Our ref: *D2020/17318*

SSD 9601 Horsley Park Brickworks Plant 2 Upgrade – Response to Submissions

Thank you for your email dated 6 February 2020 requesting WaterNSW's comments on the submission report prepared by WillowTree Planning for the above project.

**Figure 7 | Proposed Stormwater Detention/ Sediment Basin**

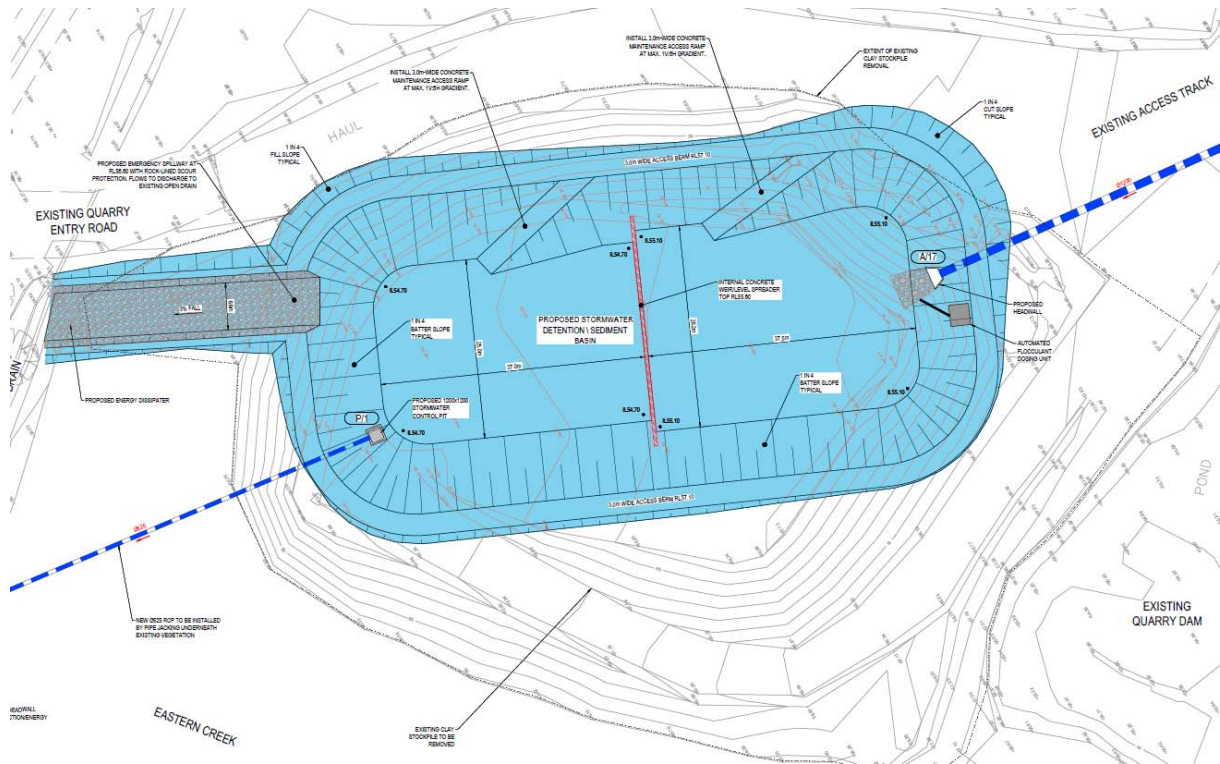
Our requirement that the post-development stormwater discharge flows must be equal to or lesser than current conditions stands. AT&L notes within table 8 of the response document that '*the quantity of flows into Eastern Creek are limited to equal or less than pre-development levels by the proposed OSD basin*', however no supporting evidence with results is provided to support this claim. Pre-development flows must be identified against post-development flows discharging offsite. Showing that the peak discharge flows meet the allowable permissible site discharge (PSD) requirements set by the local council is insufficient. As noted by AT&L, revised flood modelling would be the ideal process and is requested by WaterNSW.

The maintenance of the onsite detention basins is crucial to ensure it functions as designed. It is still unclear what provisions are in place to ensure it receives ongoing maintenance to prevent failure. As per Fairfield Council's Stormwater Management Policy, WaterNSW request an onsite detention basin maintenance plan and schedule be prepared to ensure effective operation and maintenance of the basin.
